March 9, 2023

Ref: Slab Edge Depth
Buies Creek Fire Department
112 Marshbanks St
Buies Creek, NC 27506
Sanford Metal Buildings Cont.

TYPICAL LUG FOOTING DETAIL - 1
Scale: 3/4" = 1'-0" x3

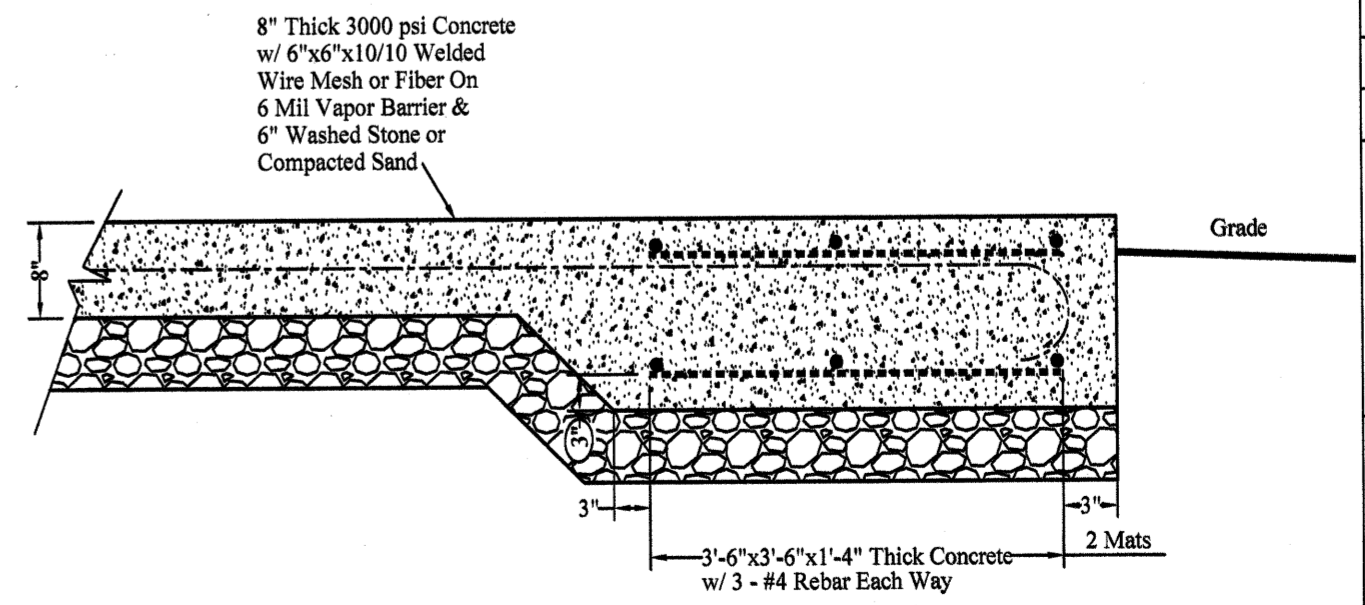
It will be acceptable to place compacted backfill against the exposed drop lug wall footings to achieve the minium bottom of footing depth of 12 inches for protection against frost heave.

The backfill is acceptable and will meet the requirements of the N C Building Code 2018,ed.
